# A1 Birtley to Coal House

## Scheme Number: TR010031

### Applicant's Responses to ExA's Second Written Questions - Appendix 2.10D - Meeting Minutes with Environment Agency and WSP

Figure 4 - Revised Flood Plain Compensation Area (shown on orange)

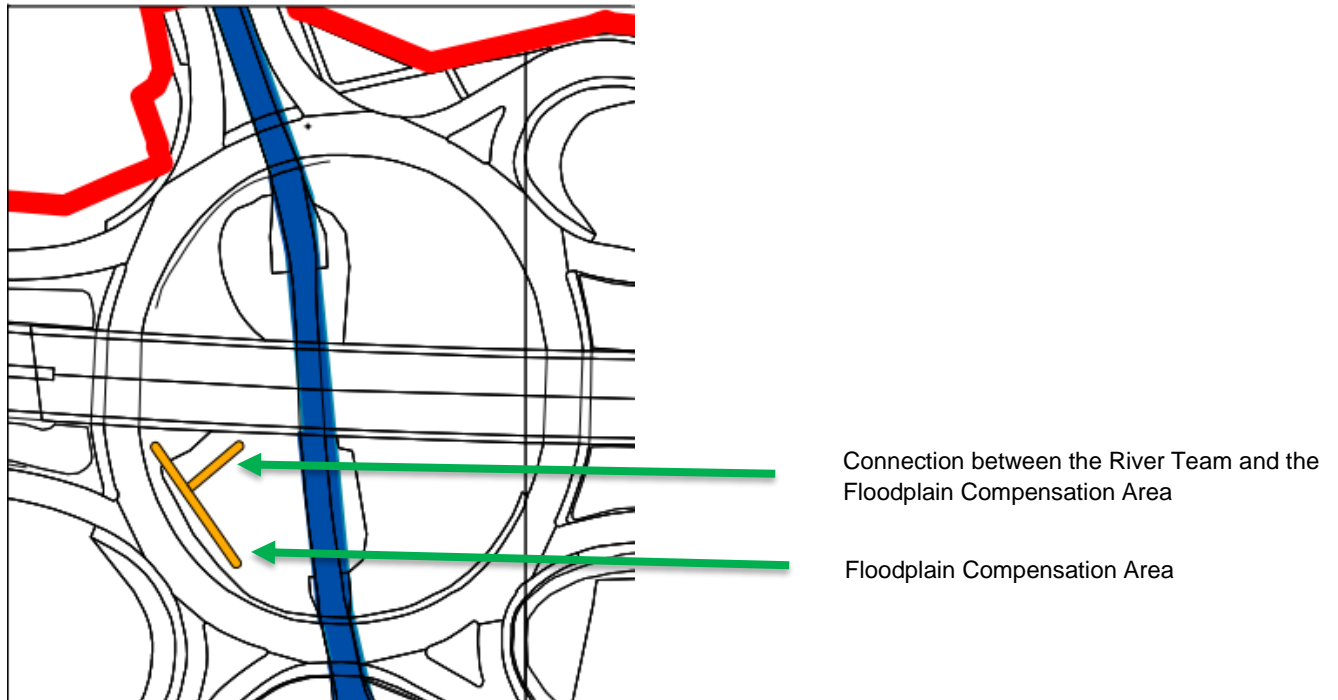
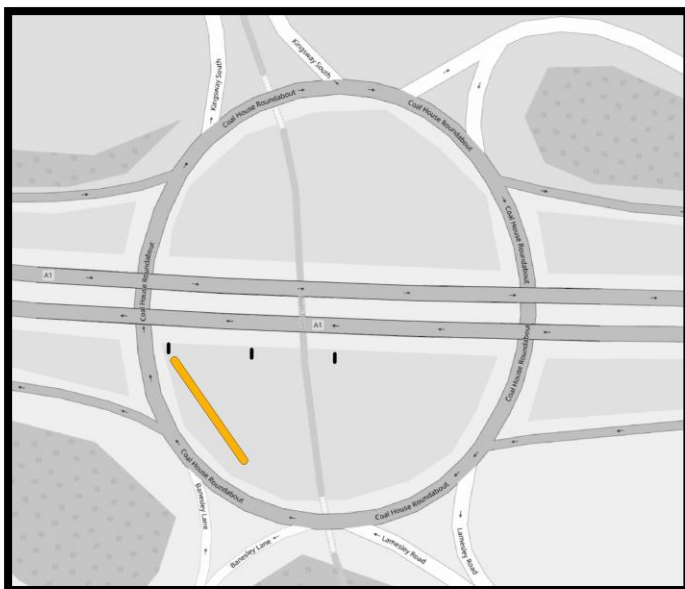
<p>█ discussed that they were sent via usb stick to the offices but may not have made it to the relevant people due to lock</p> <p>█: WSP has assessed the worst-case scenario which has been submitted as part of the Allerdene Three Span Viaduct addendum.</p> <p><b>Action:</b> █ to send a link to the Addendums to the EA █.</p>	█	Complete
2	<p><b>Flood risk (model and FRA approval)</b></p> <p>█ and █ outlined that they have approved the flood model, however, they require additional clarification on the operation of the flood plain compensation.</p> <p><b>Compensation areas</b></p> <p>█ asked if the local authority (Gateshead Council) has agreed the location of the attenuation crates within the Coal House roundabout.</p> <p>█ discussed that with regard to flood compensation on the opposite bank to the attenuation crates as shown in ES Figure 13.7: Flood Plain Compensation Area, the EA are concerned that in their interpretation of the written representations flood plain compensation is only provided for the climate change scenarios.</p> <p>█ stated that modelling shows that for the non climate change scenarios the flows are within the banks – impacting 12m<sup>2</sup> of the area, only additional piers (max 2 piers in future that will require the provision of flood compensation for the climate change scenarios in the roundabout area).</p> <p><b>Action:</b> █ to confirm that the location of these attenuation crates is confirmed within the SoCG with Gateshead Council.</p> <p><b>Action:</b> █ to include technical note in the SoCG of how flood compensation will work.</p>	█

Figure 4: Sketch of the proposed temporary works

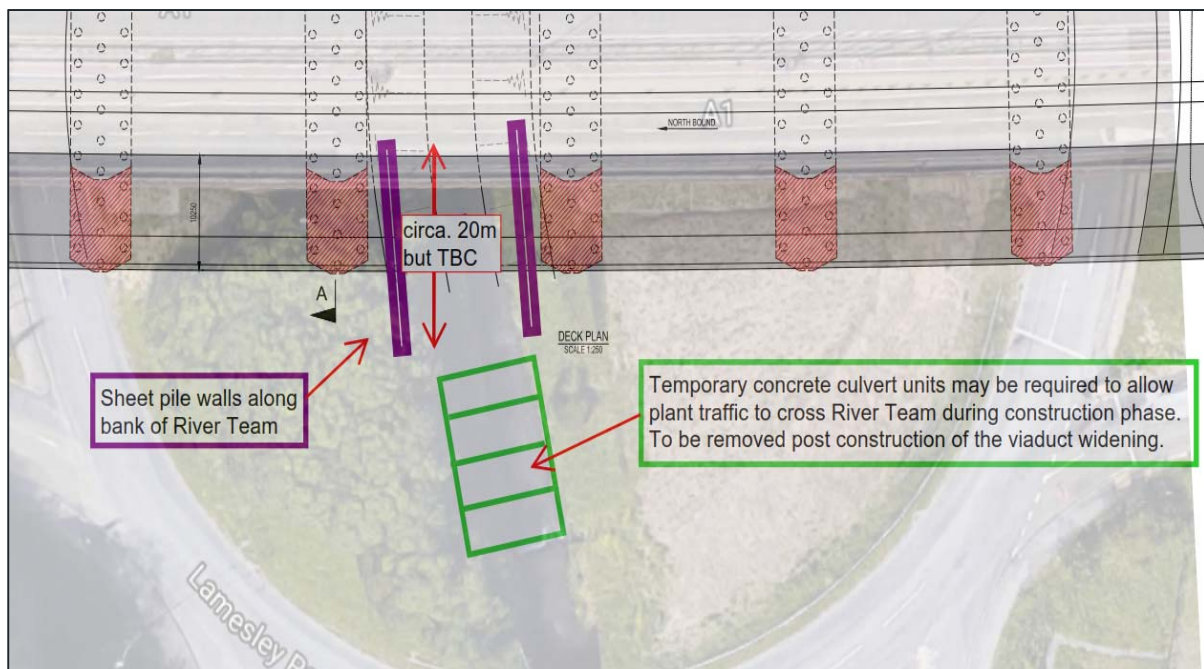
<p>4</p>	<p><b>Temporary Works – Hydraulic Modelling</b></p> <p>█ highlighted that temporary works can alter flood risk – for example culverting short lengths can increase flood risk temporarily during construction, and asked when the EA would be able to see modelling information?</p> <p>█ stated that no modelling of temporary works has currently not been completed.</p> <p>█: WSP have assessed the worst-case scenario as submitted in the Allerdene three span viaduct addendum.</p>	<p>█</p>

<p><b>Action:</b> EA to provide information how temporary works will affect forecasts and if validity of the gauging station will be removed.</p> <p><b>Action:</b> ■■■ to undertake hydraulic modelling of the temporary works culvert and provide a Technical Note outlining the impacts on the gauging station in the SoCG.</p>		
5	<p><b>WFDa (if Environment Agency wish to discuss)</b></p> <p>■■■ stated that the EA approve the WFDa.</p>		
6	<p><b>Biodiversity</b></p> <p>■■■■■■■■■■ not present. All ecology issues will be picked up in the upcoming meeting on 6 April 2020.</p>		
7	<p><b>Statement of Common Ground</b></p> <p>■■■ discussed that once all actions points in this meeting are addressed, the EA will be in a position where the SoCG can be formalised and agreed.</p> <p>■■■ stated that the draft SoCG will be submitted at Deadline 4 (20<sup>th</sup> April), comments on SoCG at Deadline 5 (1<sup>st</sup> May) and a final version to be completed by Deadline 8 (7<sup>th</sup> July).</p>
